DECISION DELEGATED TO HEAD OF PLANNING

Application No: H01-0981-23 **Applicant:** Mr & Mrs S Pywell
Proposal: Details of external materials (Condition 4 of H01-1011-22)
Location: 44 Backgate Cowbit Spalding
Terminal Date: 29th December 2023

FRONT ELEVATION

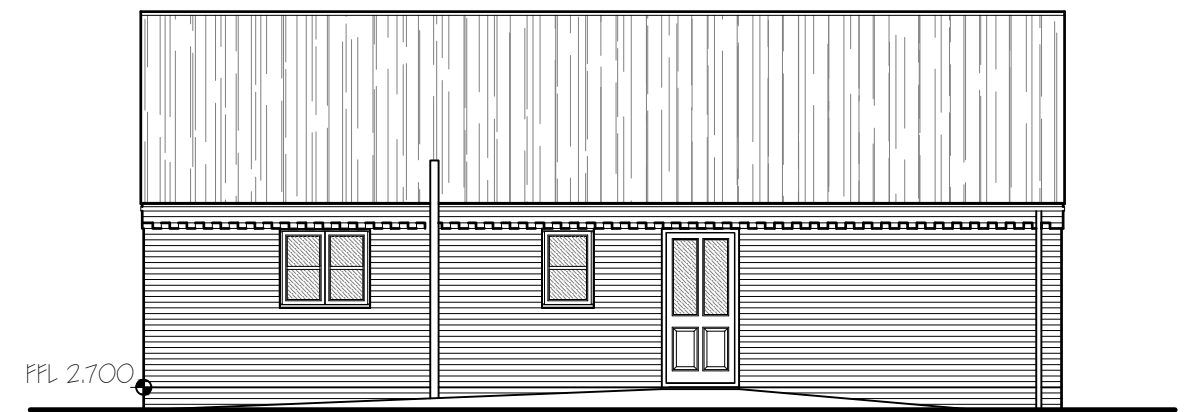
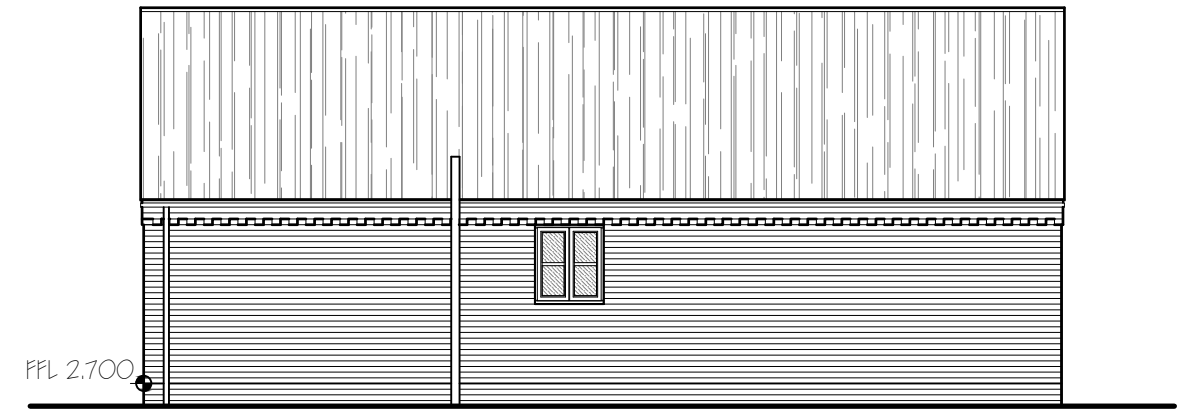
The bricks are proposed as Vandersanden Flemish Antique, which is a mixture of light and brown mixed types to give a mottled appearance. This is a modern design and the appearance in the street scene will be acceptable. The proposed bricks will not adversely affect the character of the area or immediate locality.

The roof tiles are Planun Smooth anthracite grey roof tiles which will complement the brick type and give a modern appearance to the dwelling in the street scene. No adverse impact on character.

Rainwater goods are in black, windows are in white UPVC. These details are considered acceptable.
